Appeal Decision

Appeal Ref: APP/R5510/W/20/3261227
60 Long Lane, Ickenham UB10 8SZ

- The appeal is made under section 78 of the Town and Country Planning Act 1990 against a refusal to grant planning permission.
 - The appeal is made by Greengables against the decision of the Council of the London Borough of Hillingdon.
 - The application Ref 70282/APP/2020/2522, dated 11 August 2020, was refused by notice dated 29 September 2020.
 - The development proposed is demolition of existing dwelling and erection of two storey detached building with habitable roof space to provide 9 x 2-bed flats with associated amenity space and parking.
-

Plan 746.17.3A Tree Protection Plan

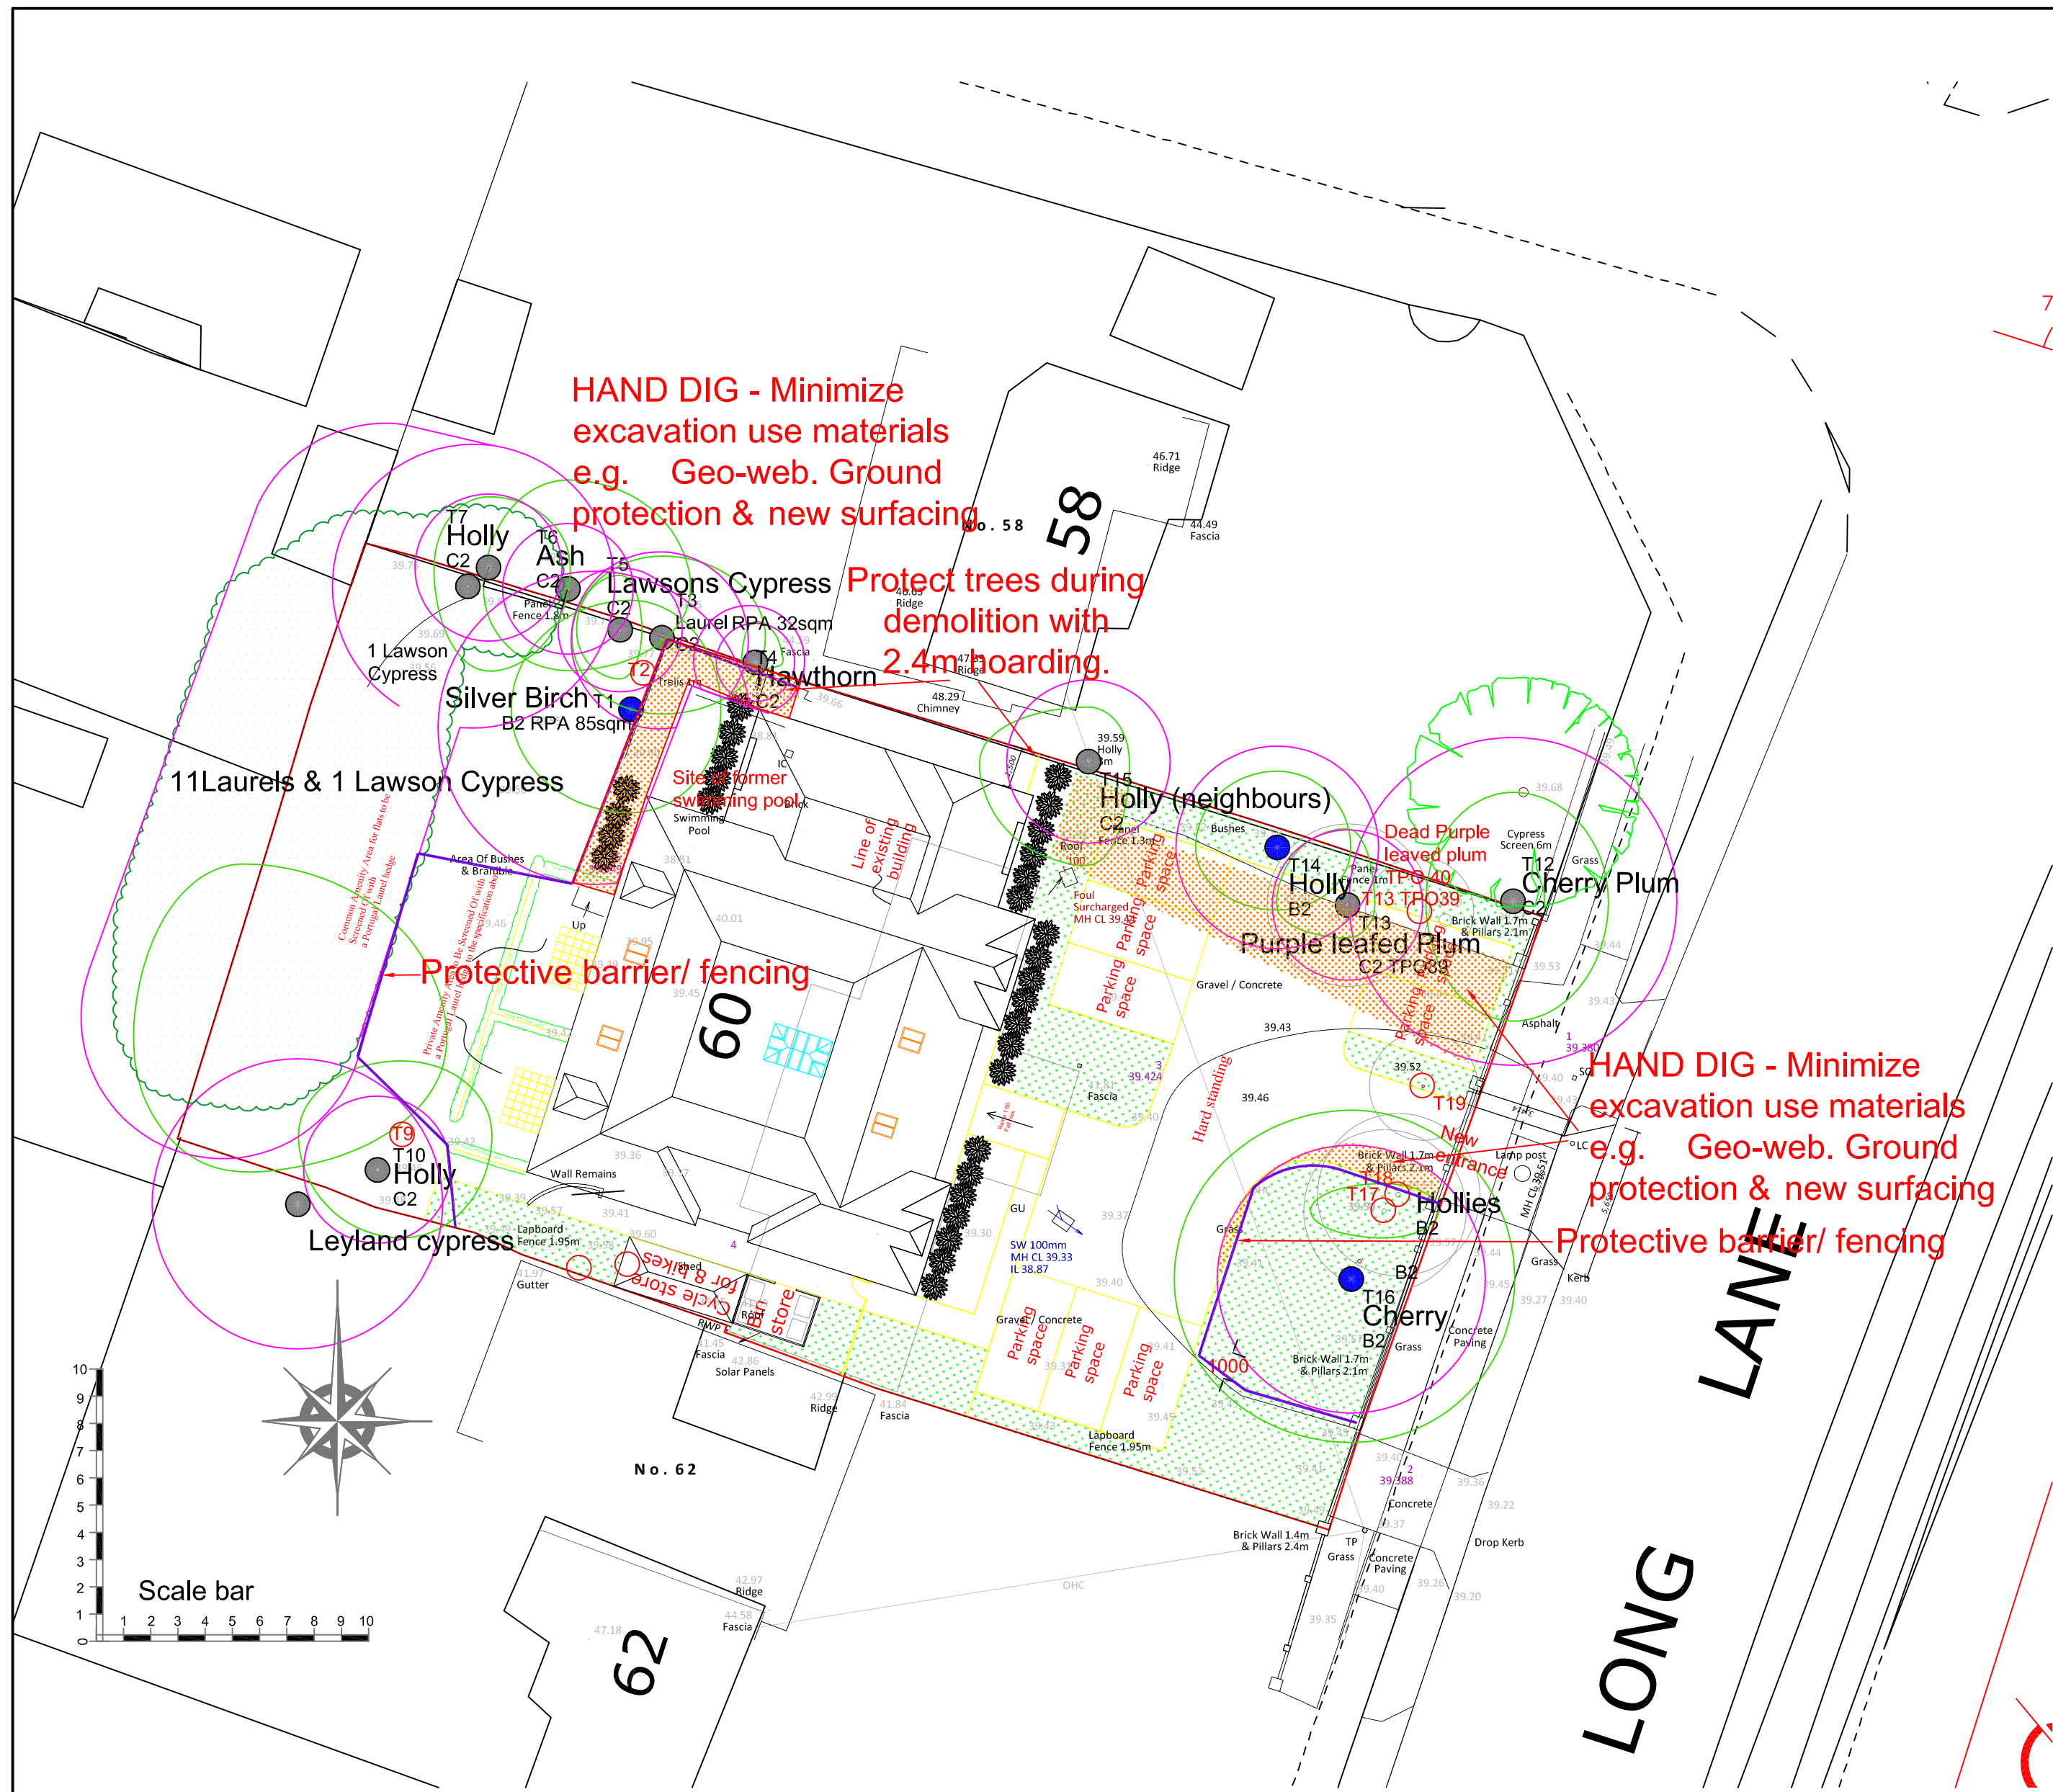
18. The proposed site plan shows that the laurels adjacent to the rear boundary would be retained. To my mind, given that it is a natural feature, vegetation should not itself be relied upon in perpetuity to provide privacy screening for neighbouring properties. Nevertheless, it provides some benefit and a landscaping condition could be imposed to require the retention and management of the trees. The views afforded from the proposed ground and first floor rear windows towards the neighbouring gardens would be comparable to the rear windows approved as part of the previous planning permissions. I consider that the level of separation to the main outdoor amenity areas of No 1 Neela Close and No 1 Milton Road would maintain sufficient privacy for neighbouring occupiers.

NORTH WEST ELEVATION

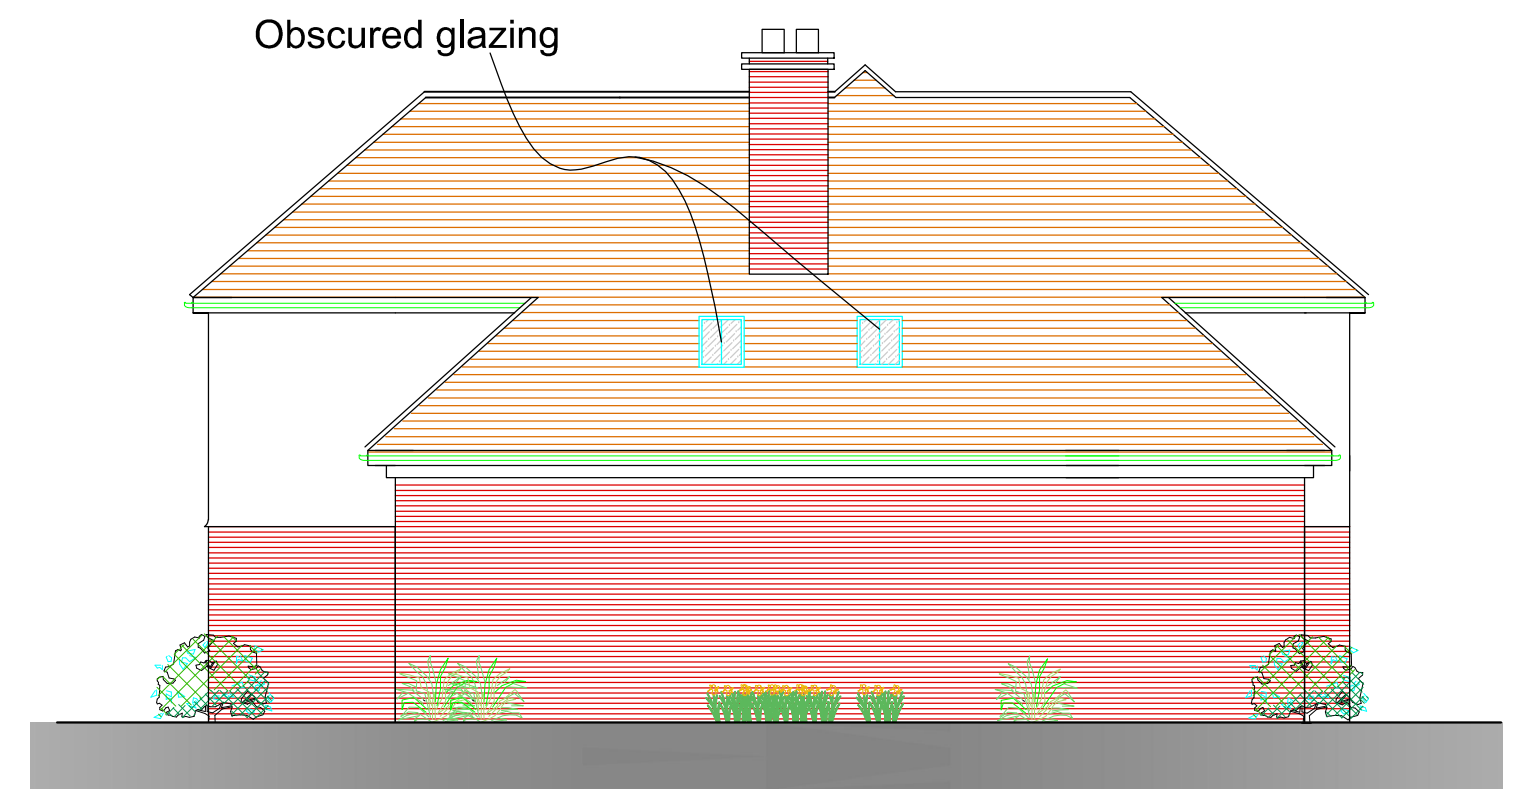
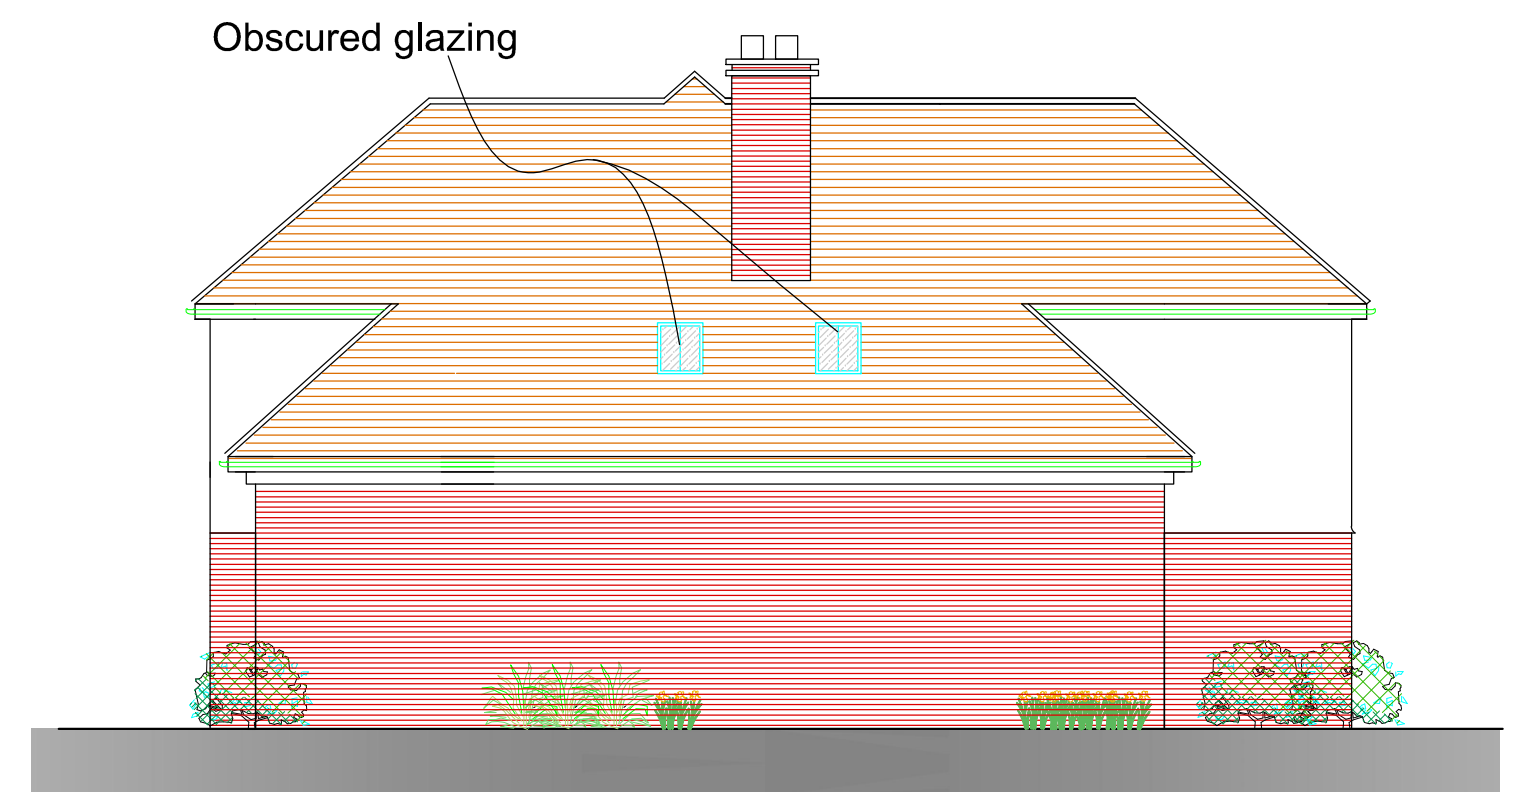
8. The main alteration in respect of the current proposal relates to the design of the rear elevation. The previous planning permissions showed that the pitched main roof would slope down to a low eaves line at the rear, with 2no 2-storey hipped rear projections and 2no centrally positioned first floor dormer windows. This would provide a well-articulated elevation and appropriate massing, with hipped rooflines and projecting elements. It would provide an acceptable appearance and respect the form and massing of neighbouring buildings.

9. The current appeal scheme proposes a very wide 2 storey rear element with a large crown roof and 3no second floor rear dormer windows, which would create a bulky and dominant feature to the rear of the building. The crude form of this element would not reflect the considered design approach of the front elevation, and it would appear out of keeping with the pitched roof forms and massing of neighbouring dwellings. I note that the block of flats at No 66 Long Lane features a crown roof, however, this is anomalous in the area as the dwellings generally have modest ridge apex roofs. Whilst there would be limited views of the rear elevation in the street scene, it would nevertheless be visible from neighbouring dwellings and gardens within the CA. Furthermore, the lack of visibility from the public realm does not obviate the need to achieve good design.

19. I acknowledge that the elevated position of the proposed second floor dormer windows would enable views across the rear gardens of No 1 Neela Close and No 1 Milton Road. Nevertheless, the appeal site is in a settlement and so a degree of overlooking of gardens is to be expected. The proposed second floor dormer windows would be set back around 1 metre from the rear wall of the proposed building and so they would be further from the neighbouring gardens than the windows on the floors below. Having regard to the degree of separation maintained to the outdoor amenity areas immediately adjoining the rear elevations of No 1 Neela Close and No 1 Milton Road, I find that the proposed second floor dormer windows would not cause an unacceptable level of overlooking.
